Our reference: P-1181695-F5P0
Contact: Sandra Fagan
Telephone: (02) 4732 7992

**Council Advice on the Modification Report for SSD-9138102-Mod-7 –
Westlink – Stage 1 – MOD 7 – Warehouse 3 Operation at 290-308
Aldington Road, KEMPS CREEK**

Council has reviewed the information referred for comment on 05 June 2026 and provides the following advice for the Department's consideration:

Figure 3 Mamre Road / Abbotts Road Intersection – Interim Traffic Signals (Stage 2 upgrade)

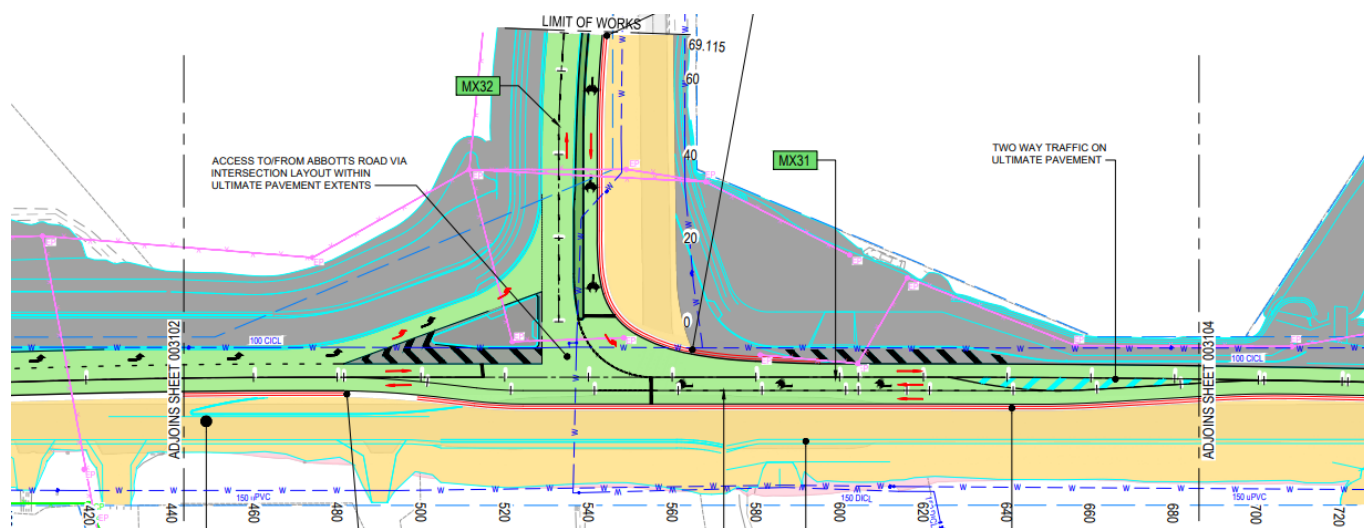
- a) The design of the interim signalised intersection as referred to in the submitted documents appears to be different to the interim signalised intersection as approved by the current consent, Appendix 7 table 5 MR536 Mamre Road and Abbots Road Kemp's Creek 2000 Series – Proposed Signalised Intersection Civil Works Package 80% Detailed Design.

- b) The proposed interim design appears to have a single left and right turn lanes from Abbots Road, whereas the consent approved interim design has two left and right turn lanes from Abbots Road.

- c) Whilst in principle there are no objections to the proposed modification subject to Transport for NSW's concurrence, further design detail is required on the interface between the upgraded Abbots Road and the proposed new interim signalised intersection. The design is required to clarify the lane arrangement along the westbound lanes of Abbots Road and the approach to the signalised intersection.
